WEST SUSSEX COUNTY COUNCIL CONSULTATION

TO:	Arun District Council FAO: Jasmine Kaur Singh
FROM:	WSCC - Highways Authority
DATE:	21 May 2021
LOCATION:	2 Elspring Mead Littlehampton BN17 7JE
SUBJECT:	LU/90/21/HH Installation of drop kerb and driveway.
DATE OF SITE VISIT:	n/a
RECOMMENDATION:	Advice
S106 CONTRIBUTION TOTAL:	n/a

Block Plan Showing vehicular crossover
for 2 Elspring Mead

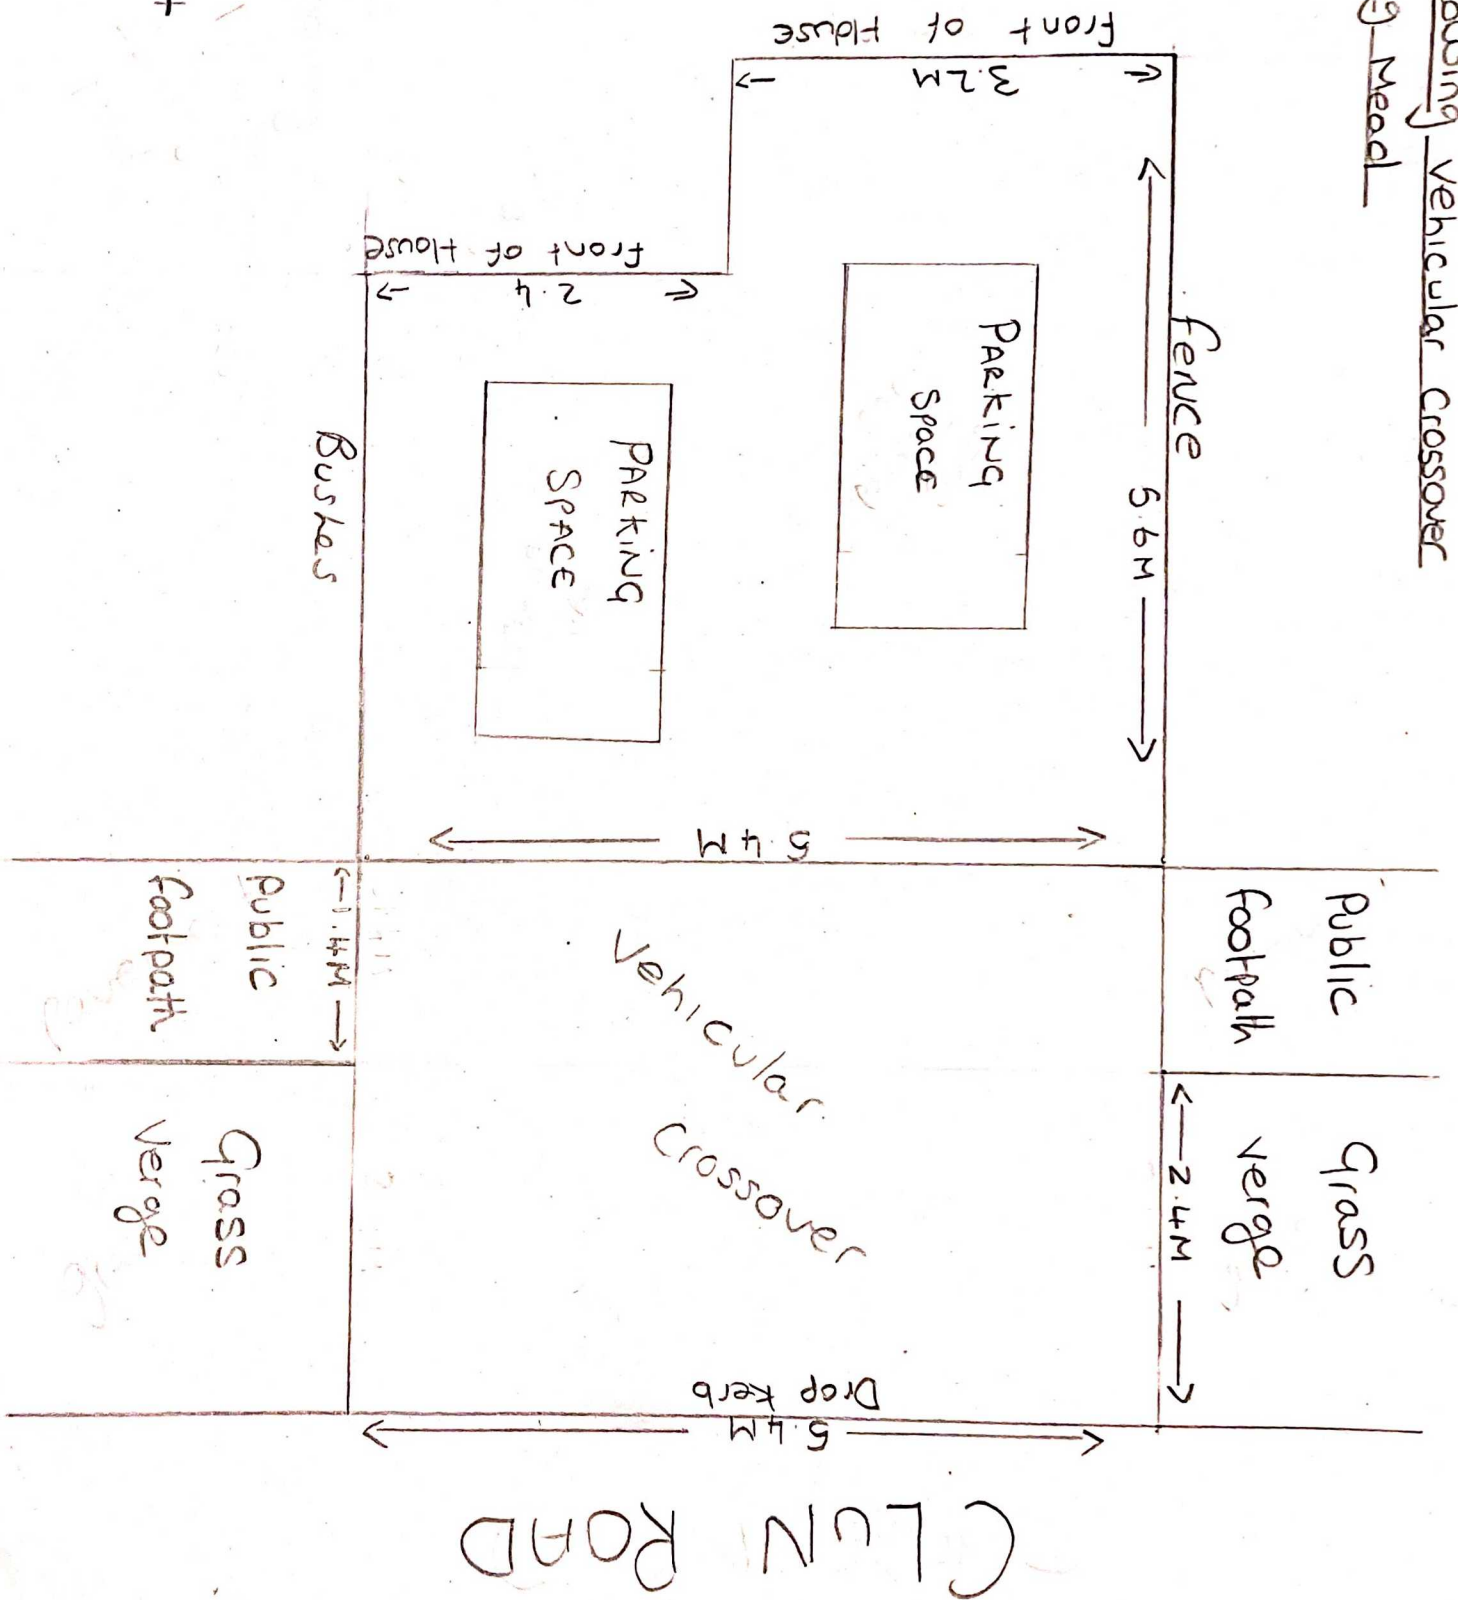
The proposed vehicular crossover (VCO) will be 5.4m wide and must be constructed to a specification agreed with the WSCC Highways Engineer. Visibility at the proposed access is sufficient for the anticipated road speeds in this location.

The proposed plans demonstrate two parking spaces on the proposed driveway. Each parking space should meet minimum specifications of 2.4 x 4.8m as set out in Manual for Streets, and in accordance with WSCC Area policy, parking spaces in front of fire escapes, such as front doors should be provided with a minimum depth of 6m. Whilst the LHA would not raise a highway safety concern to the proposal, it appears that the parking space proposed in front of the existing front door does not meet the minimum depth specification of 6m, and as such the WSCC Highways Engineer may not grant a licence for this proposal. The applicant should consider reducing the proposed driveway to provide one off-street parking space to avoid the potential of an application being approved that is not implementable.

The LHA does not consider that this proposal would have an unacceptable impact on highway safety or result in 'severe' cumulative impacts on the operation of the highway network, therefore is not contrary to the National Planning Policy Framework (paragraph 109), and that there are no transport grounds to resist the proposal. However, as above, please note that a licence for the proposal may not be granted due to insufficient depth of the site frontage in front of the means of fire escape.

The use of the car parking spaces shall not commence until such time as the vehicular access has been constructed in accordance with the details shown on the drawing titled 'Block Plan showing Vehicular Crossover'.

The use of the access shall not commence until such time as the parking area has been constructed in accordance with the details shown on the drawing titled 'Block Plan showing Vehicular Crossover'. These spaces shall thereafter be retained at all times for their designated purpose.
